About the application

Application number: 2021/90247	
What is the application for?:	Erection of dwelling following demolition of existing dwelling (within a Conser
Address of the site or building:	Hirst Clough, 4, Kaffir Road, Edgerton, Huddersfield, HD2 2AN
Postcode:

Type of comment: An objection	
Do you wish your comments to be published on the website anonymously?	Yes
Dear Ms Katie Chew Re: Application No. 2021/62/90247/W 23rd March 2021 We note that the current application is a separate and independent application to that previously approved for the Proposed Extensions at 4 Kaffir Road, Edgerton (Application Ref.: 2020/91143). On that basis, we also include as part of this formal objection, our initial objection letter, within Appendix I of this letter, which needs also to be considered as part of our representation on this matter. We also include within Appendix II, drawings Ref.: 0692/001 & 002, showing as existing and proposed elevations and floor plans. Within Appendix III, we include a series of photographs taken from Lunnclough Hall, showing the partially constructed new build external elevations, up to window head height (under Application 2020/91143). Accordingly, we

FIRST FLOOR PLAN

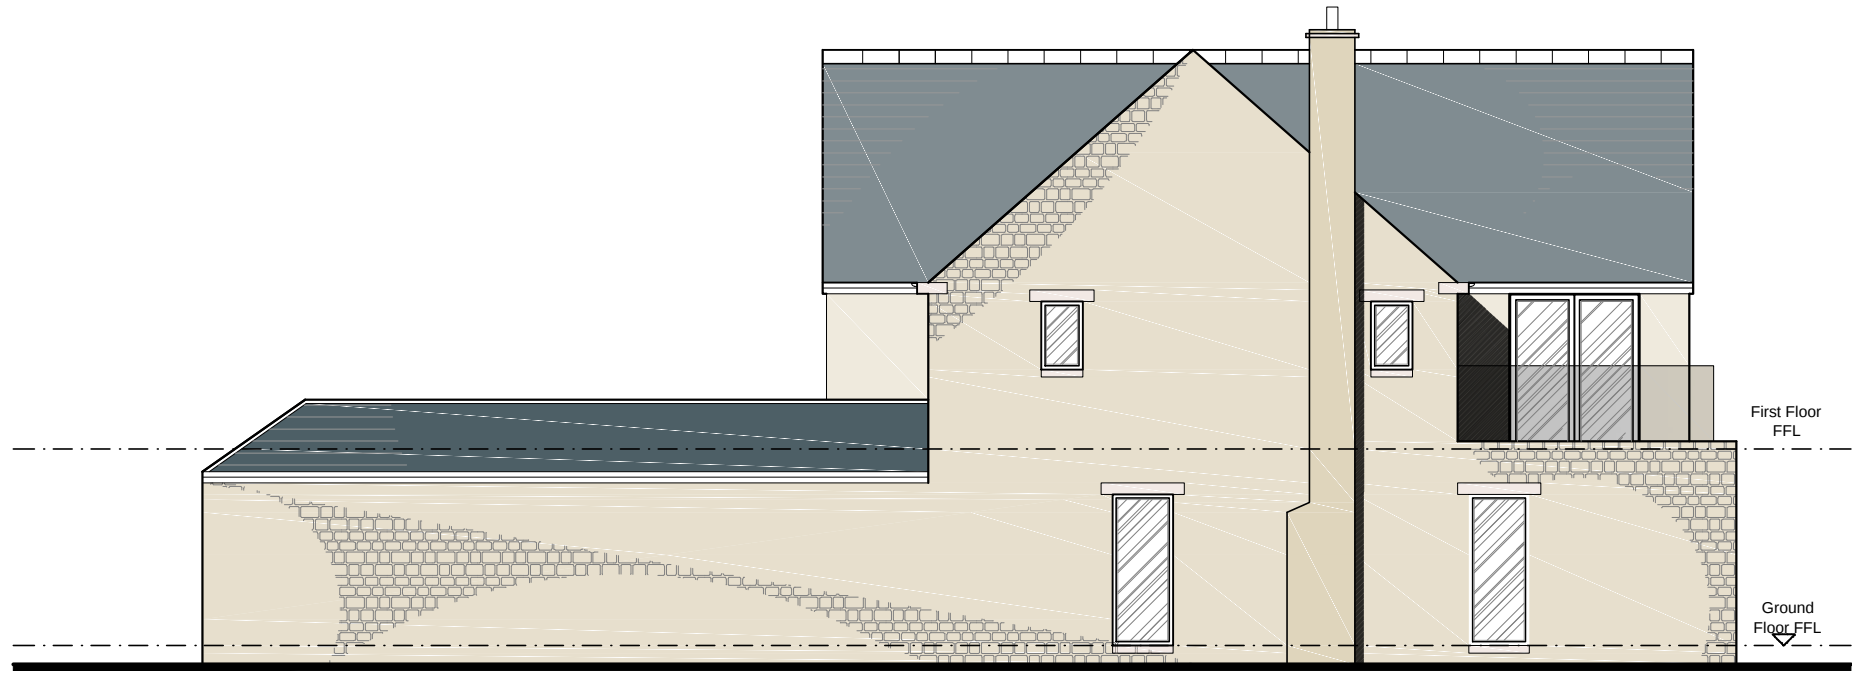
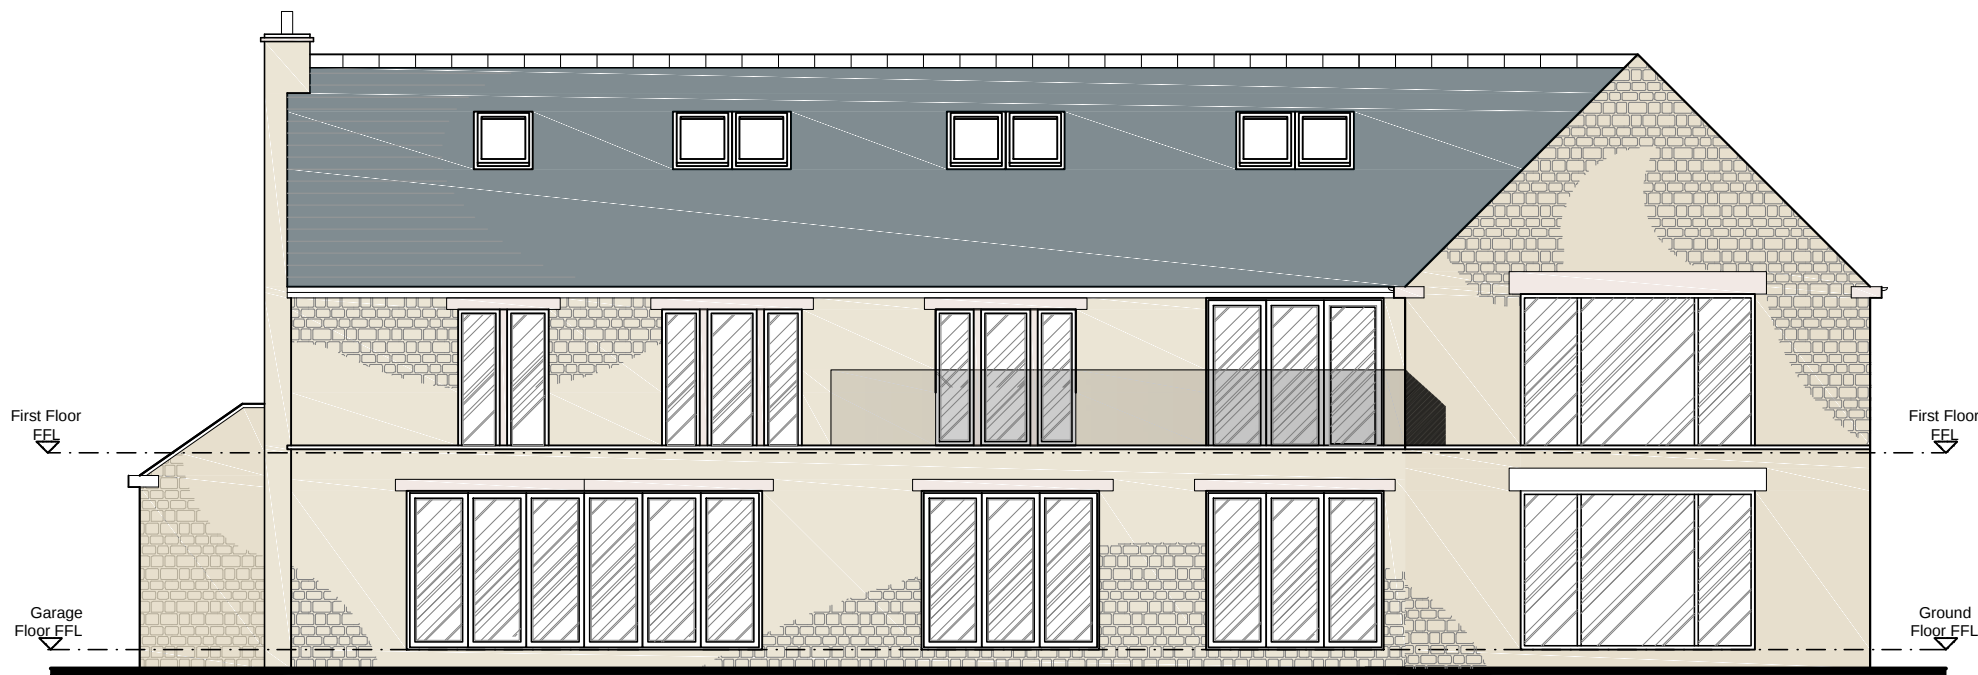
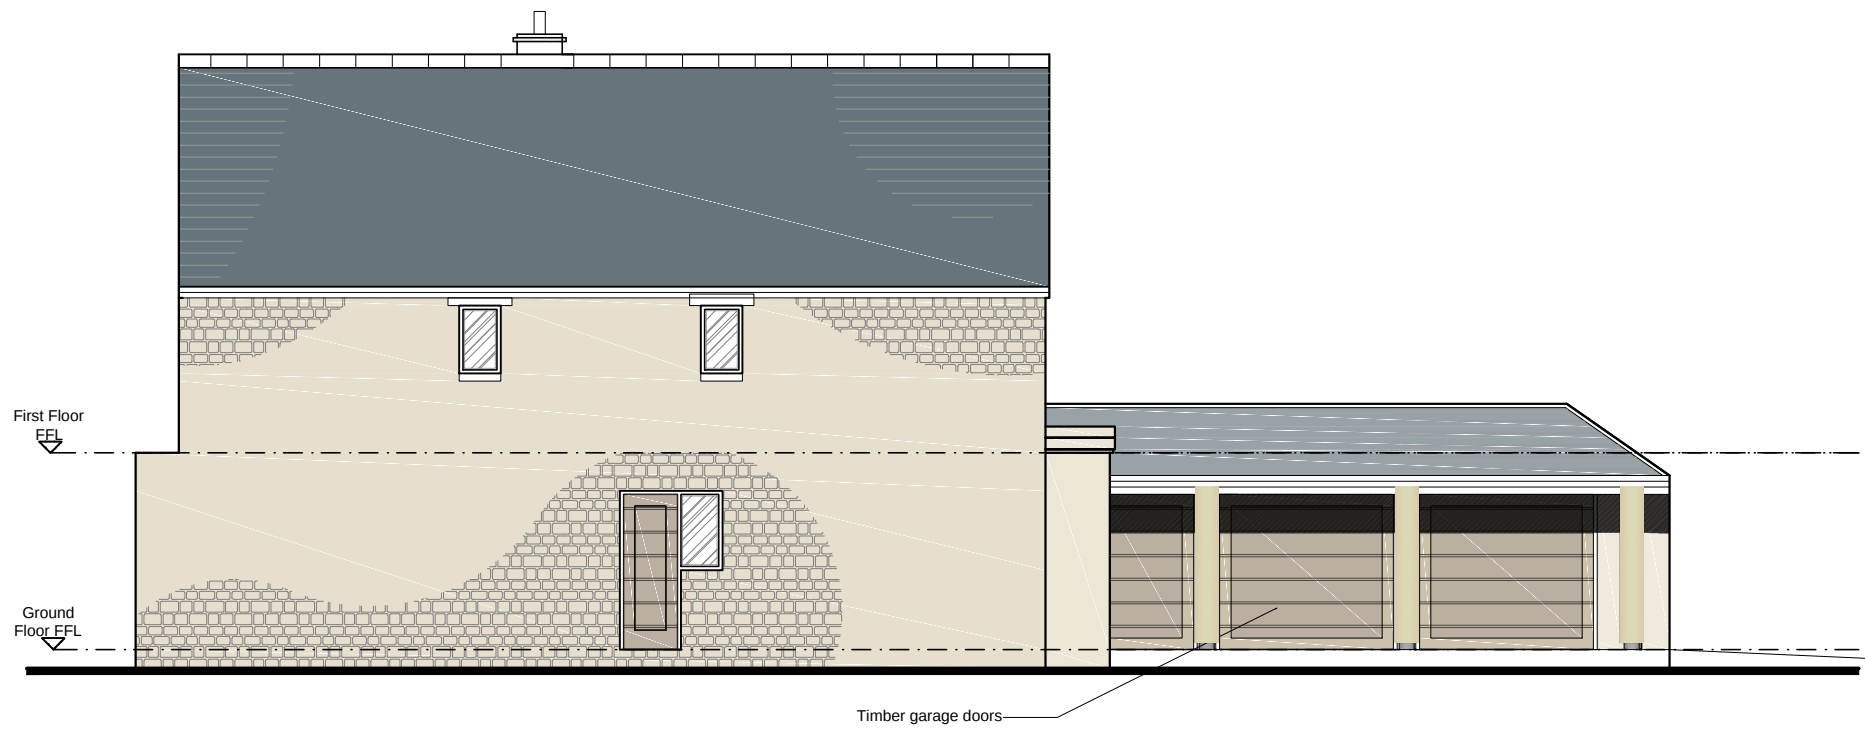
harmonious to the adjacent listed buildings; or the townscape of the wider Edgerton conservation area. The proposed building is both higher and substantially larger in terms of its footprint on the site. The footprint on plan is 316 m² (circa 621 m² taking into account ground, first and second floor areas). The proposed property, including the additional bedroom and en-suite bathroom within the attic/roof space, is in excess of three times larger than the existing house and associated buildings it is to replace (Please see attached photographs taken 21/03/2021 contained within Appendix III). The existing house presently has 36 normal height glazed openings within the various external elevations, along with a small, glazed conservatory at the rear. The proposed development has 72 glazed window openings, of which 36 are double height; considerably more than previous applications in both the front, rear and side elevations. We are also concerned that the re-siting of one of the roof peaks on the front elevation from above the front door detracts from the architectural merit of the design and could have been designed to facilitate a future extension over the triple garage, or later subdivision of the house.

4. From a safety perspective, adding an additional floor to the property will create the opportunity for an additional 54 m² of floor space, and a possible three further bedrooms

within this area. This is in addition to the six proposed bedrooms included at first floor level.

It is not unlikely that the applicant would undertake this increase in bedroom capacity, quite easily without submitting further applications as the additional rooms will be subtle, not

intruding on to the external façade. Our foundation for this opinion is that the initial application drawings included for extending further bedrooms over the garage facility. It is
